Attn: Lyndsey Hayes, Planning Department, Ribble Valley Borough Council
Email: planning@ribblevalley.gov.uk
Reference: 3/2024/0038
Planning Application Number: 3/2024/0038
Grid Reference: 361789 443533
Location: Land adjacent to 8 Old Hive, Chipping, PR3 2QQ
Proposal: Proposed drilling of borehole for ground source heating purposes and associated underground pipework.

SUMMARY - Key Points of Objection

Drawing file: planx_downloads / 24_0038_Site_Plan.pdf

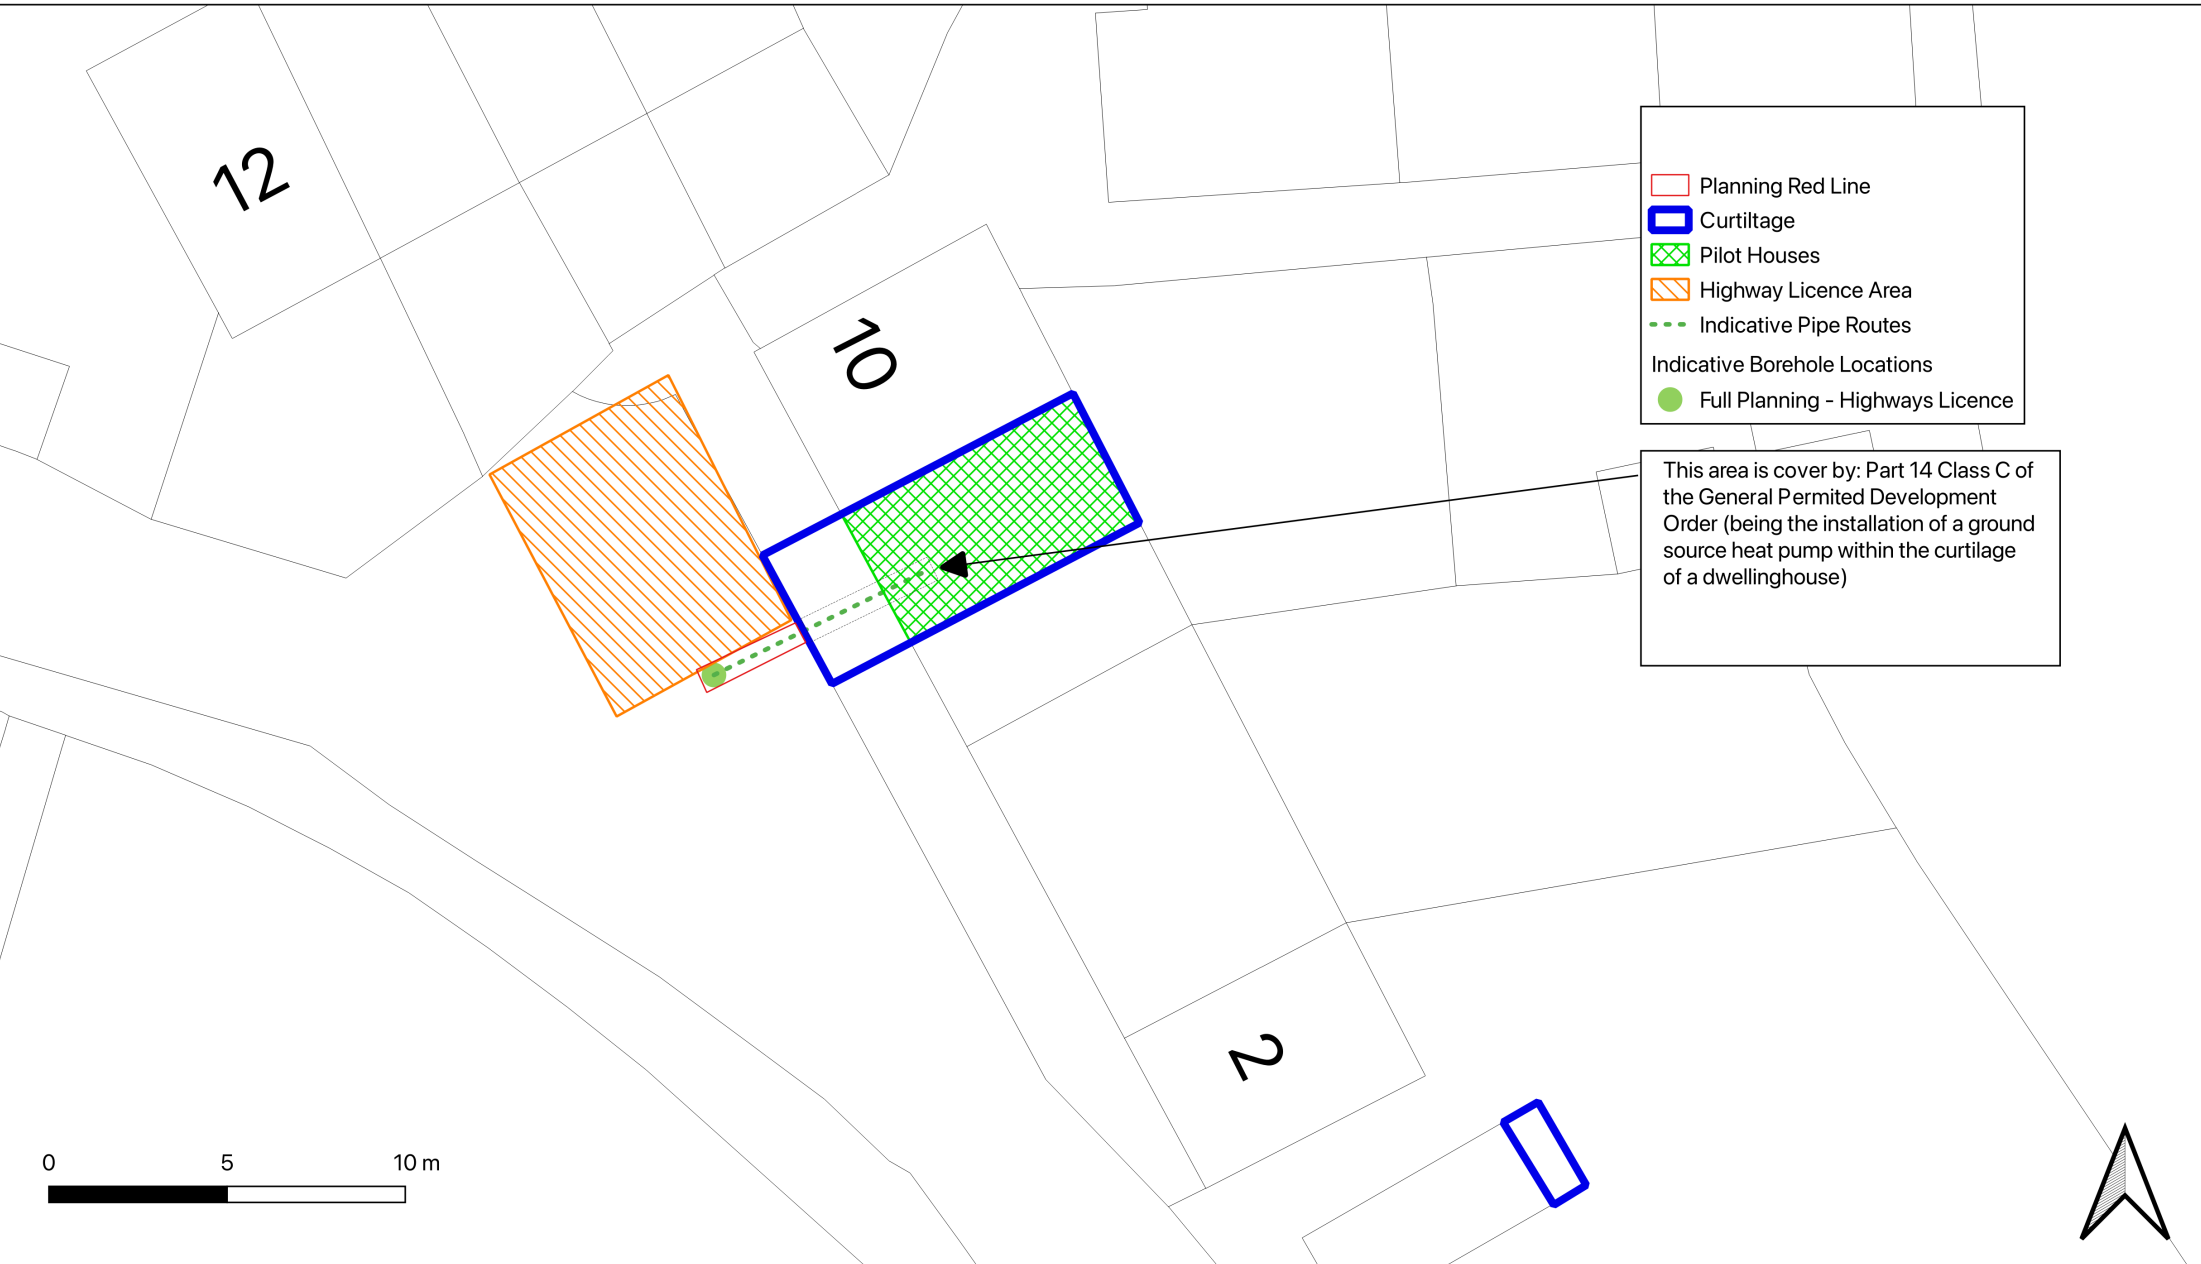
The proposed borehole installation would **NOT** be within the curtilage of the property in question (No. 8 Old Hive – PR3 2QQ), it would be situated in the middle of a public highway, within the Forest of Bowland Conservation area (AONB) - see proposed location map below. There is no provision within government policy for developments in the middle of a public highway, which will directly affect the passage of traffic and access to neighbouring properties.

This type of borehole installation requires the proposer to have sufficient external space within the curtilage of their land for the pipework and ancillary equipment. It is also critical that there is enough space for the drilling rig and accompanying vehicles to enter the proposed site. This would be very problematic within Old Hive, which is a narrow, rural road. Other drilling sites, proposed by the Community Energy Group as part of this village wide scheme, are more centrally located – here the problems manoeuvring large vehicles such as drilling rigs are likely to be even more severe. It is commonplace for trucks and lorries get stuck in the narrow streets within the centre of the village, occasionally causing damage to the heritage properties, which front them.

Chipping Community Energy Group have suggested there will be apparatus in the middle of the road but not given specific details how big this may be. In most planning applications, detailed and accurate plans of the development are required – this case should be no different. Propus and the Energy Group in Chipping need to provide specific measurements for the equipment they are planning to install at the road surface once the borehole is drilled. The schematic illustration below is taken from the Chipping

This picture is of a detached property with its own driveway and land, so not directly pertinent here, nevertheless an assumption can be made there will be a permanent box in the middle of the highway to house apparatus related to the heat pump system. There is no room directly in the cottage for this type of equipment - No. 8 Old Hive is completely open plan downstairs - a single living area comprising lounge, kitchen and dining. GSHP installations require room to house the ancillary equipment, preferably an outbuilding. This would not be feasible in this small mid-terraced cottage - the apparatus would have to be sited in the road. This will cause significant problems in terms of ownership / responsibility, it would definitely be an eyesore in this Conservation Area (AONB), but more seriously due to its siting - a high-risk safety hazard.
